## EL PASO COUNTY GRADING AND EROSION CONTROL PLAN CHECKLIST

EPC Project Number: COM2346

PROJECT NO. 196489000
 SHEET 4

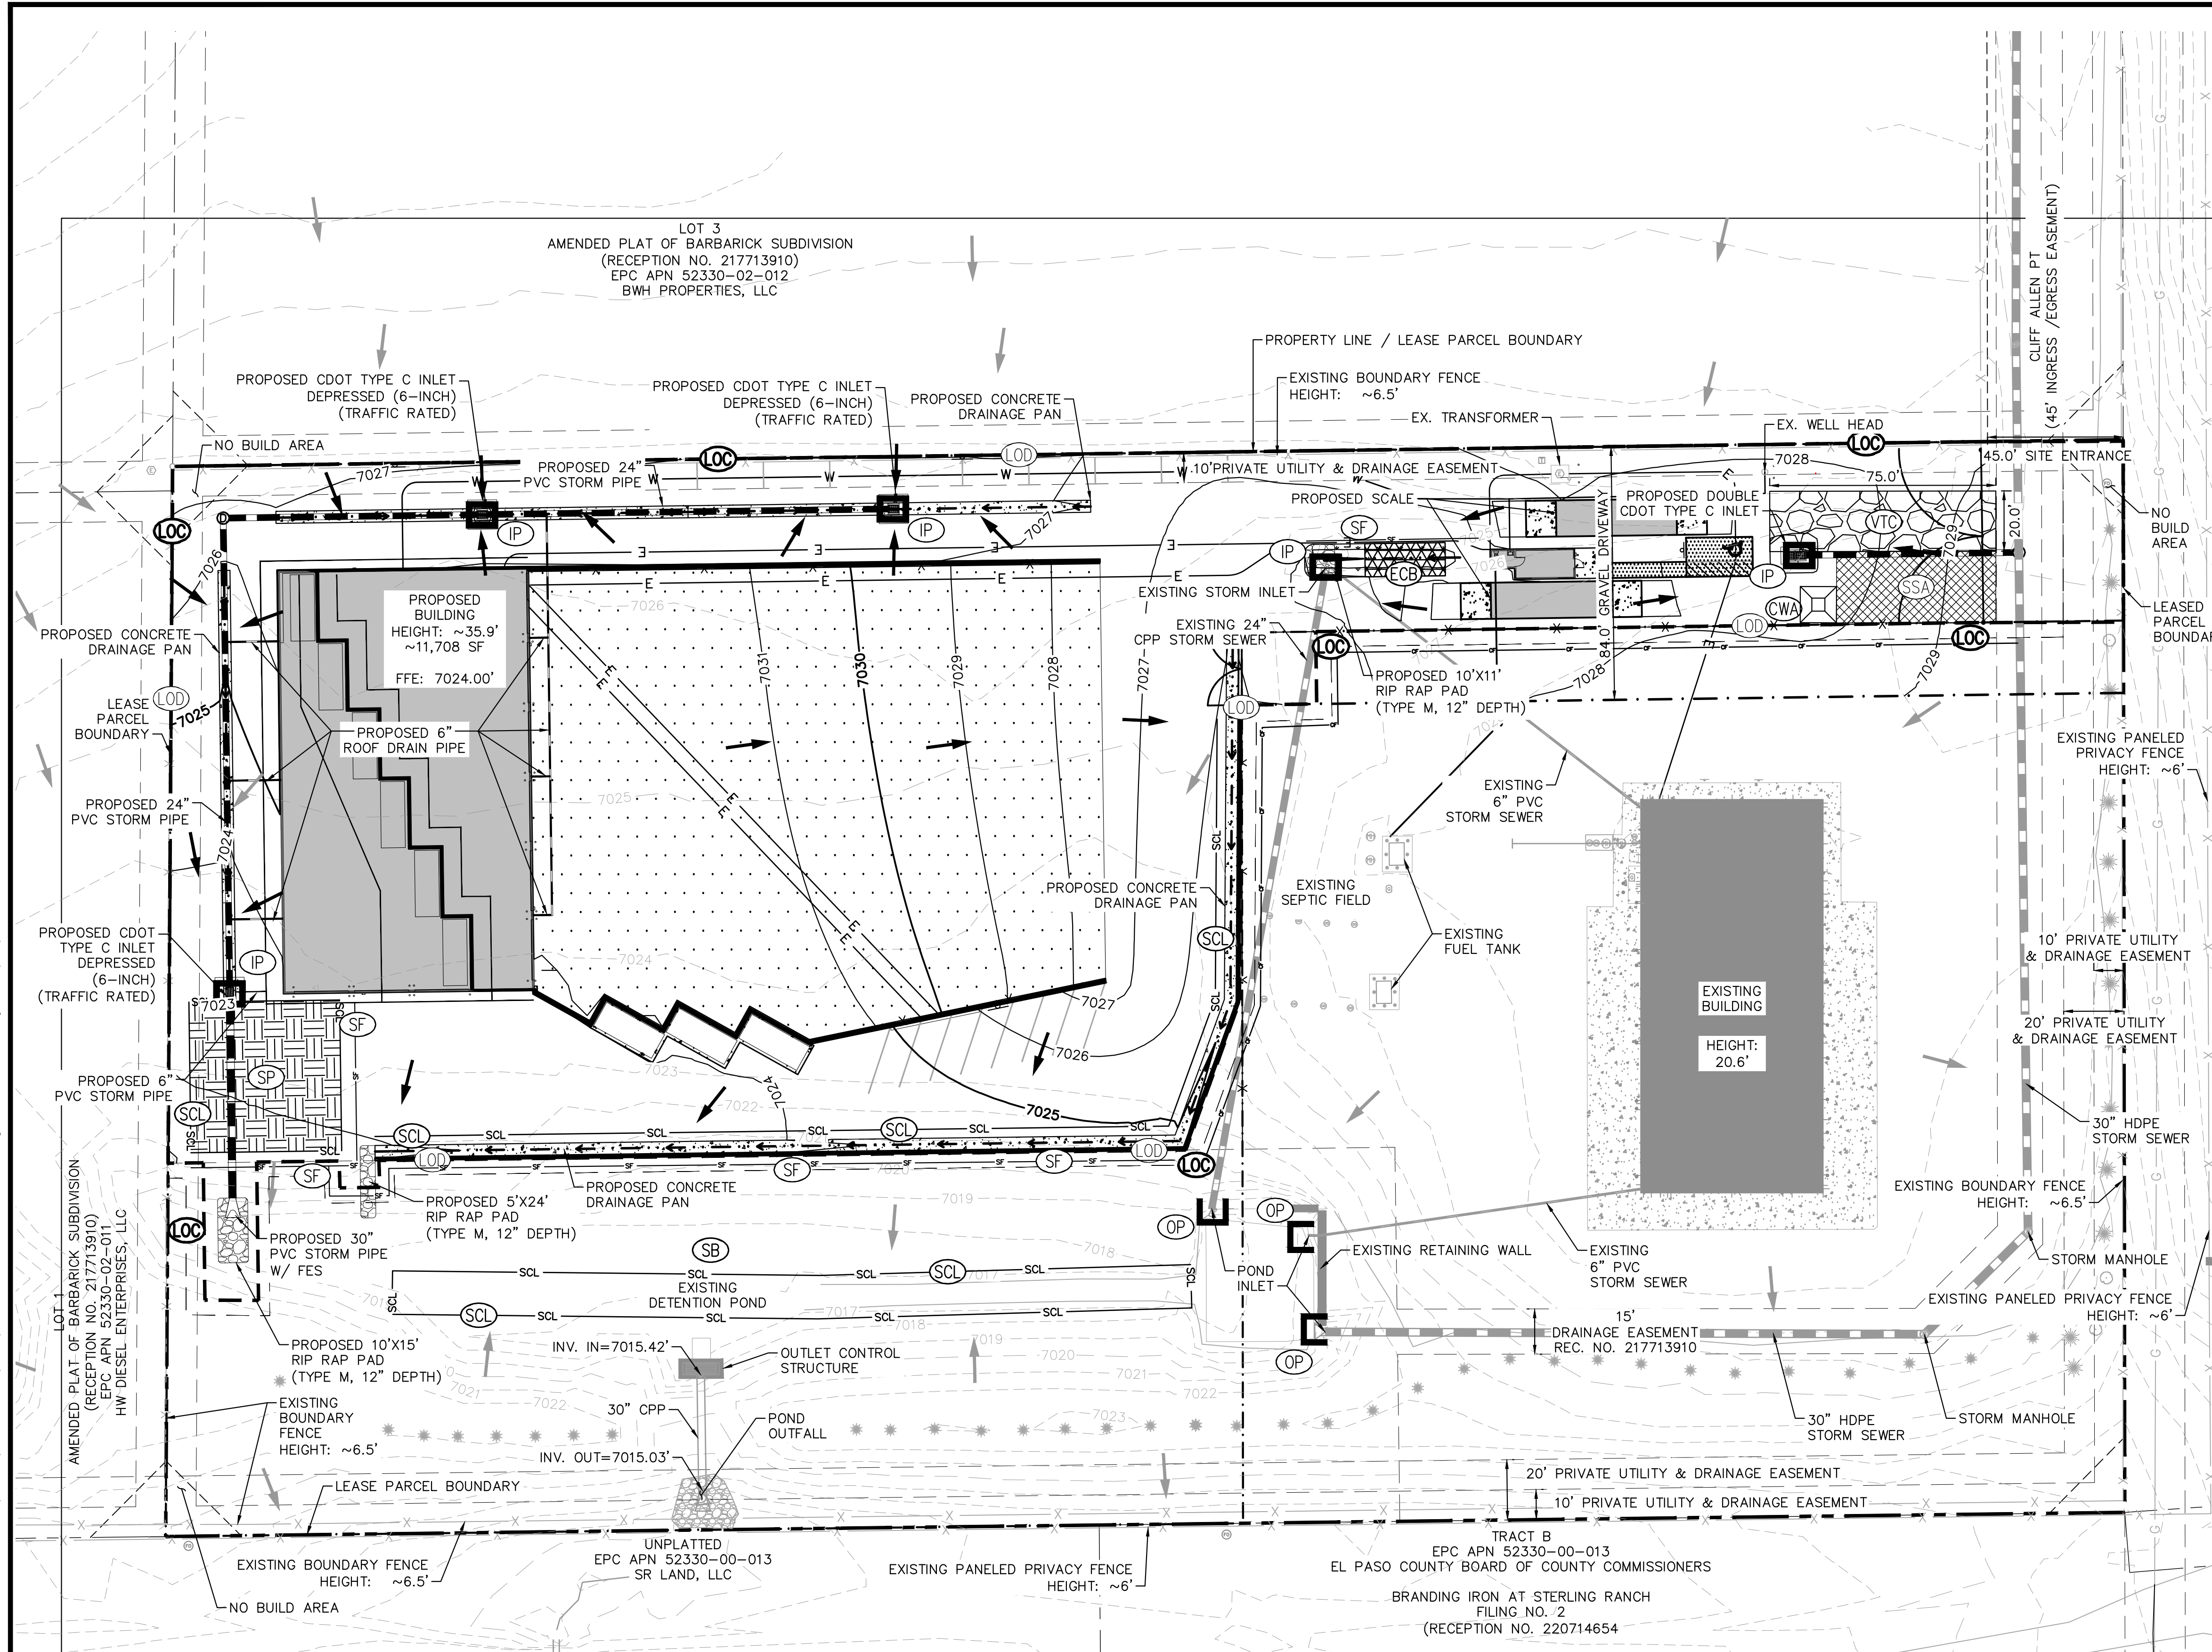
Revise to "Y" since an SB is shown on Shts 4 and 5 of GEC Plan
